**From:** F. Jackson Yonce <fjyonce@aol.com>  
**Sent:** Sunday, January 10, 2021 7:13 PM  
**To:** Ryan Howser; donnayonce@yahoo.com  
**Subject:** Forest Heights Circle Subdivision

#### COMMENTS / QUESTIONS REGARDING FOREST HEIGHTS SUBDIVISION

FOREST HEIGHTS ESTATES
FINAL PLAT.
 SW 1/4 SECTION 9, T12S, R65W, 6TH PM
 COUNTY OF EL PASO, STATE OF COLORADO

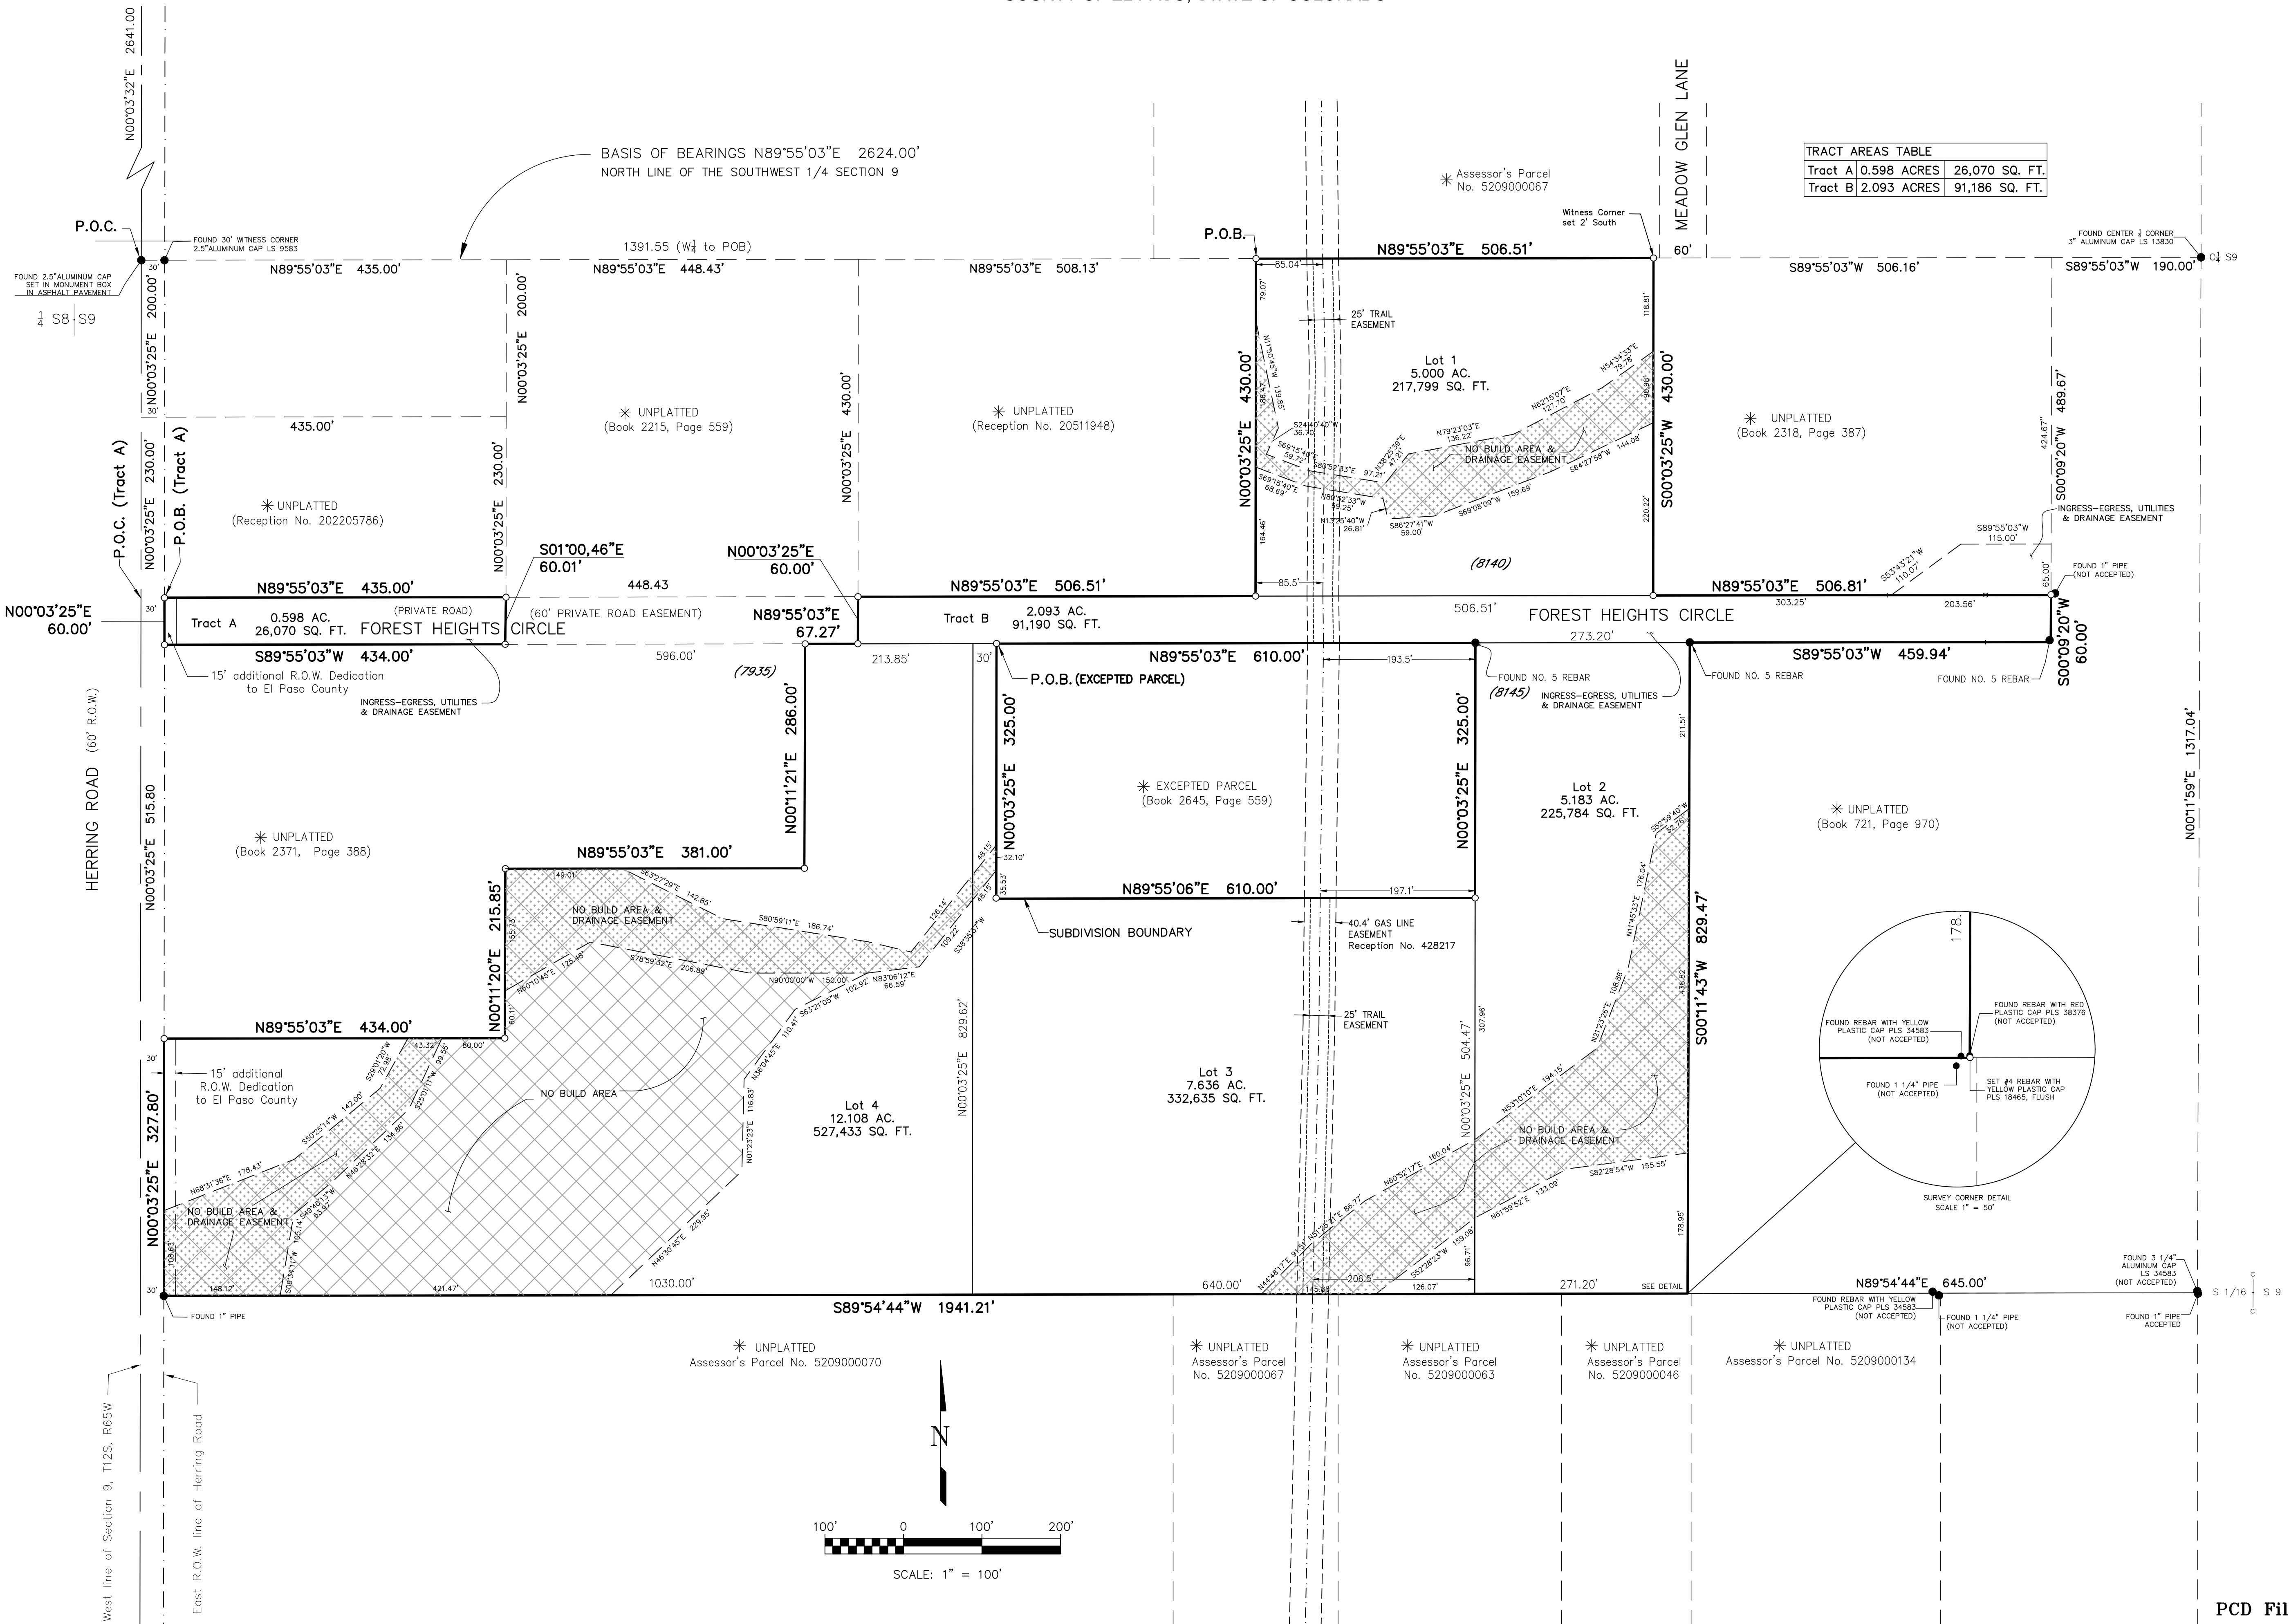
1. My property includes the road between the west and east property lines of my lot. My lot extends to the south, past the current road. It does not appear that is clear on all of the documents. Forest Heights Circle is a private road, a significant stretch of which is owned by me - the remainder by the Didleaus.

Concept Design for Roadway Improvements

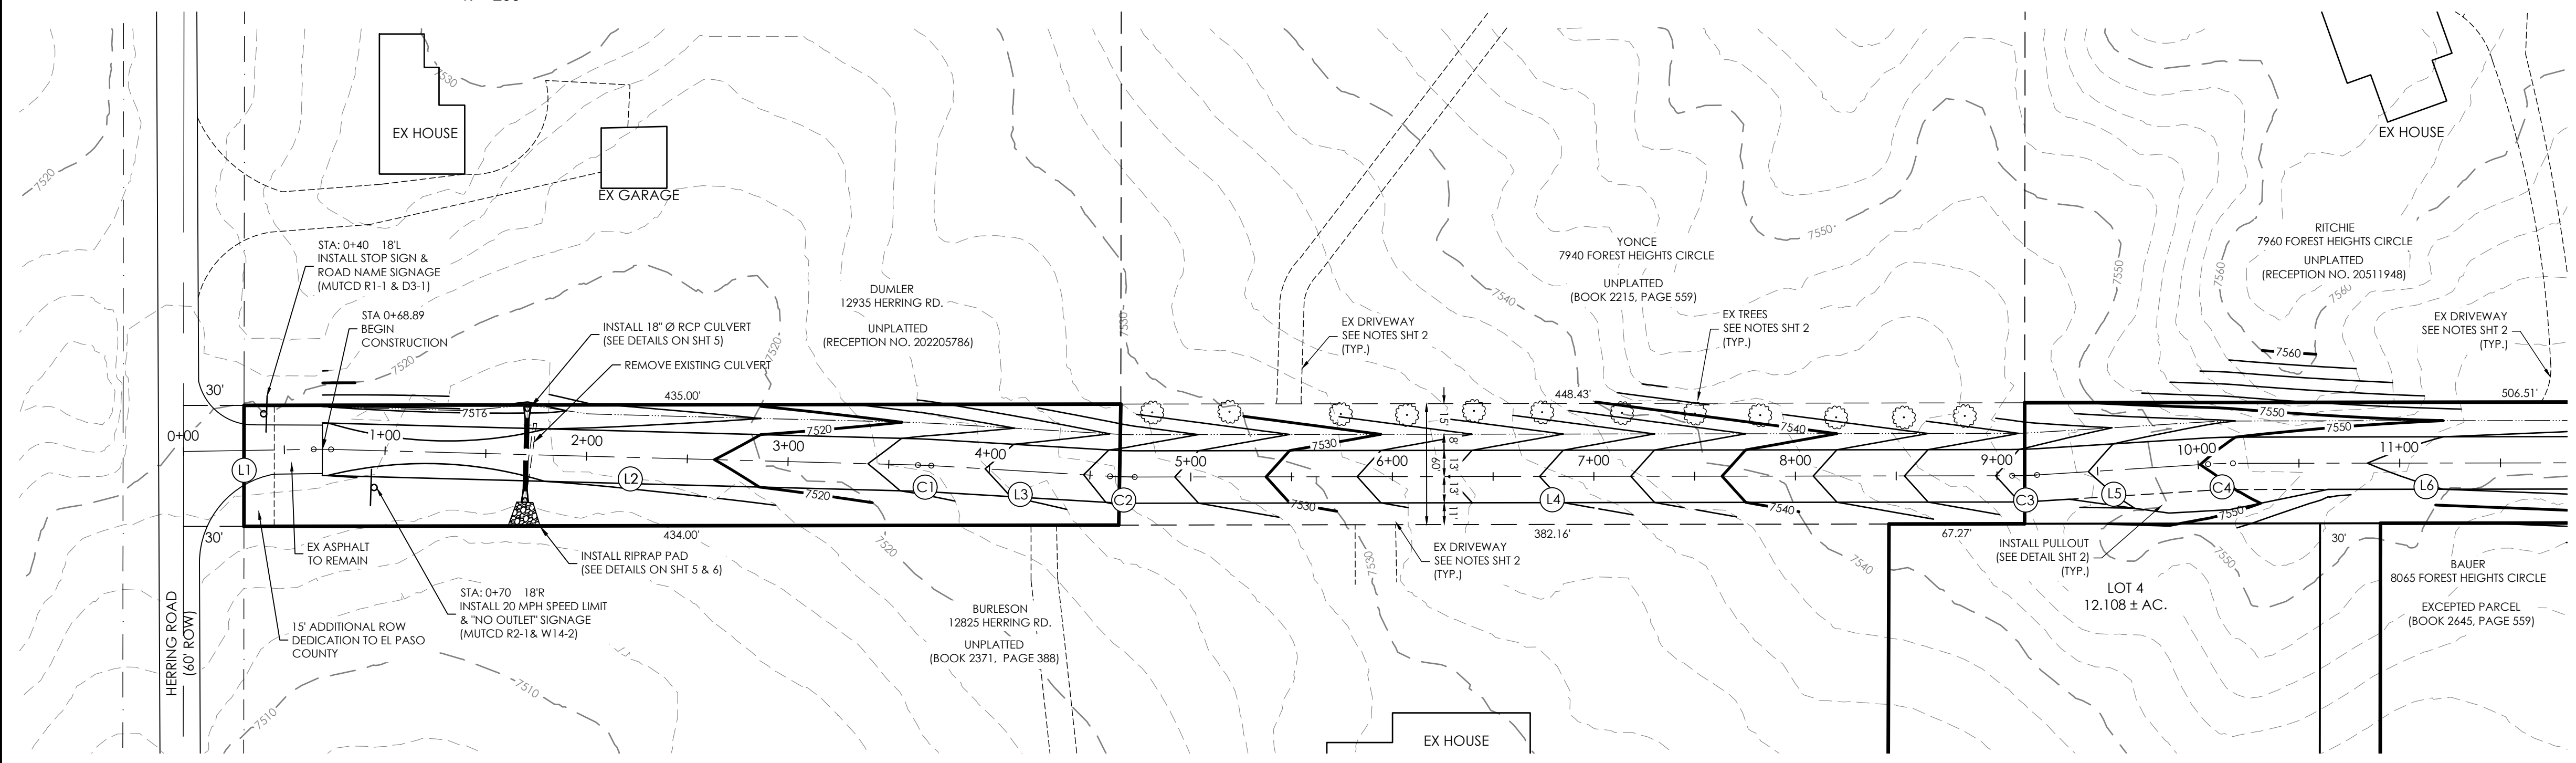
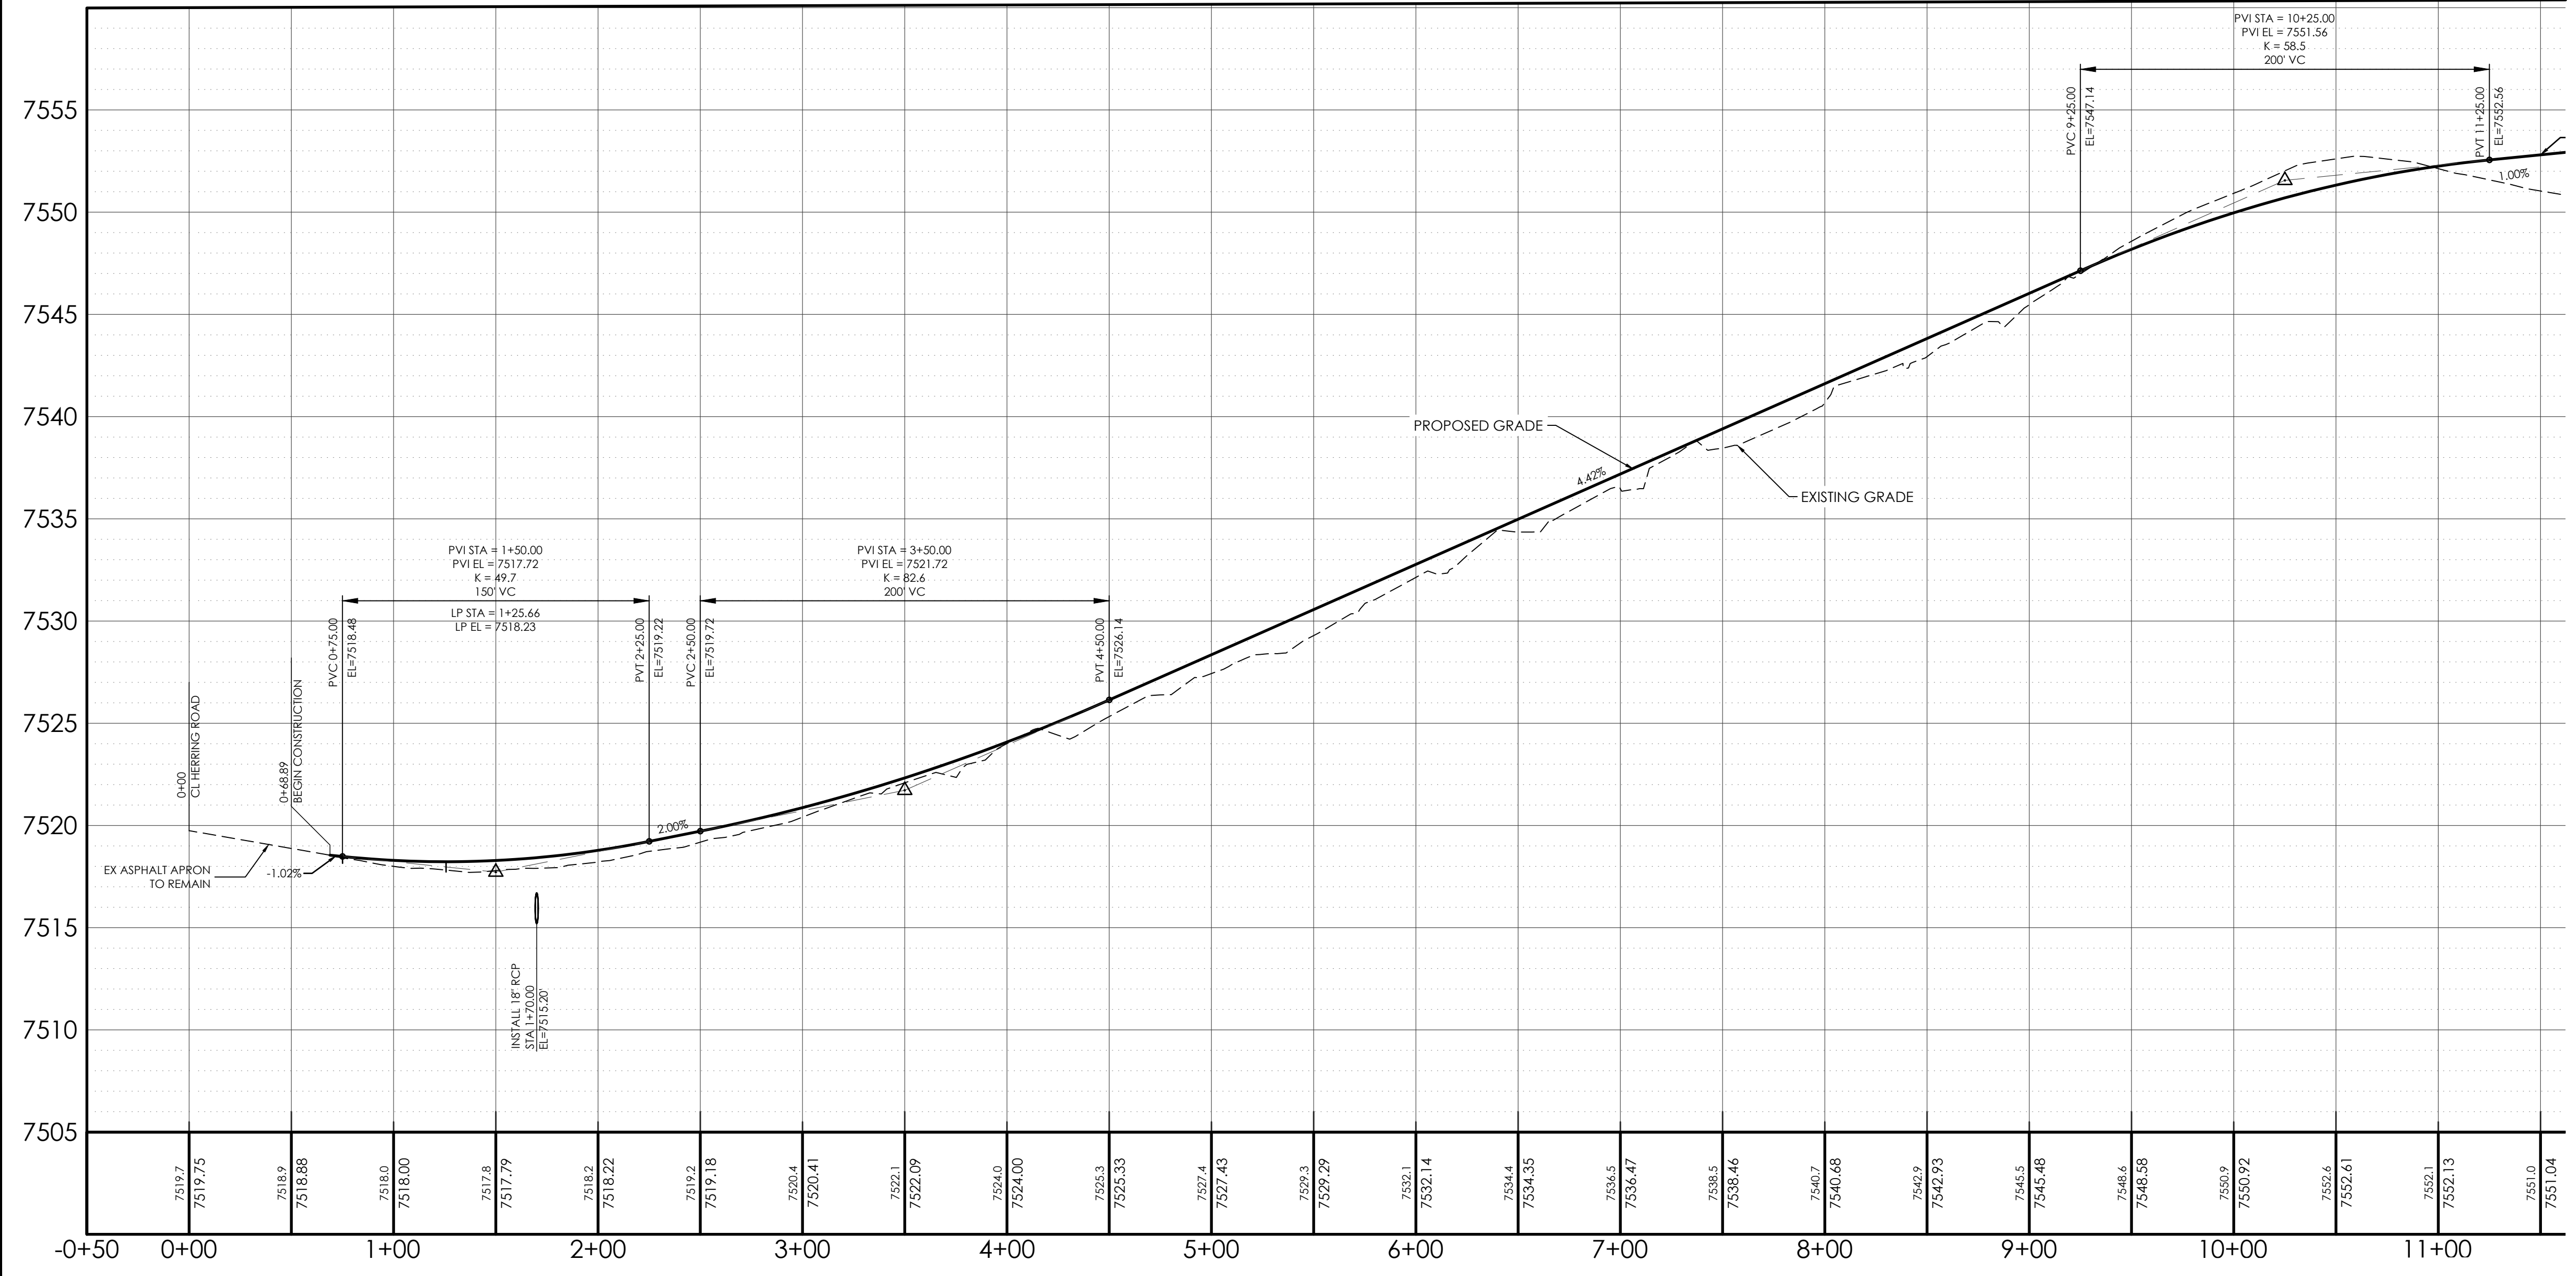
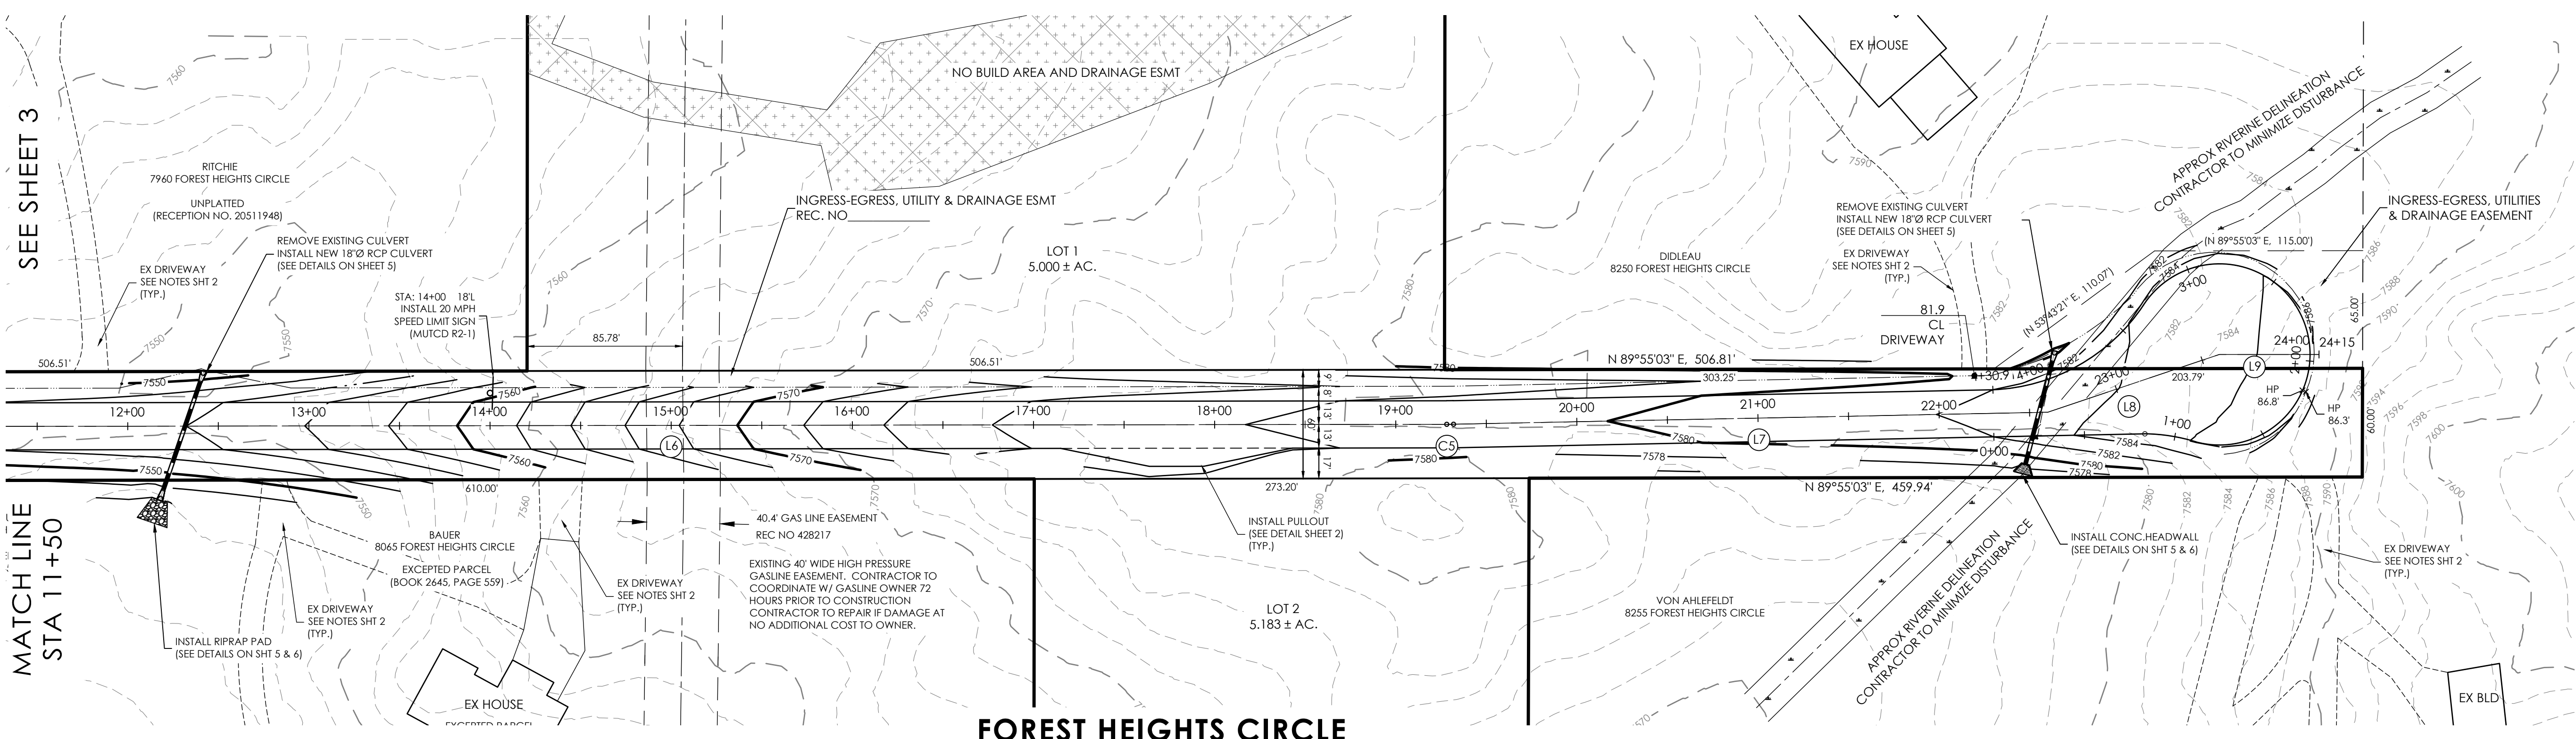
2. Since I own the road, I want it clear in the documents that any road design on my property be approved by me. Furthermore, I have discussed with Jon Didleaux my desire to have the road moved to the south where it is on my property. There is actually quite a bit of vegetation (including trees) along the north side of the road that I want preserved - we lost too much in the fire and I don't want any more removed. I have discussed this amicably with Mr. Didleaux and he agreed, however I would like that in writing in the legal documents.
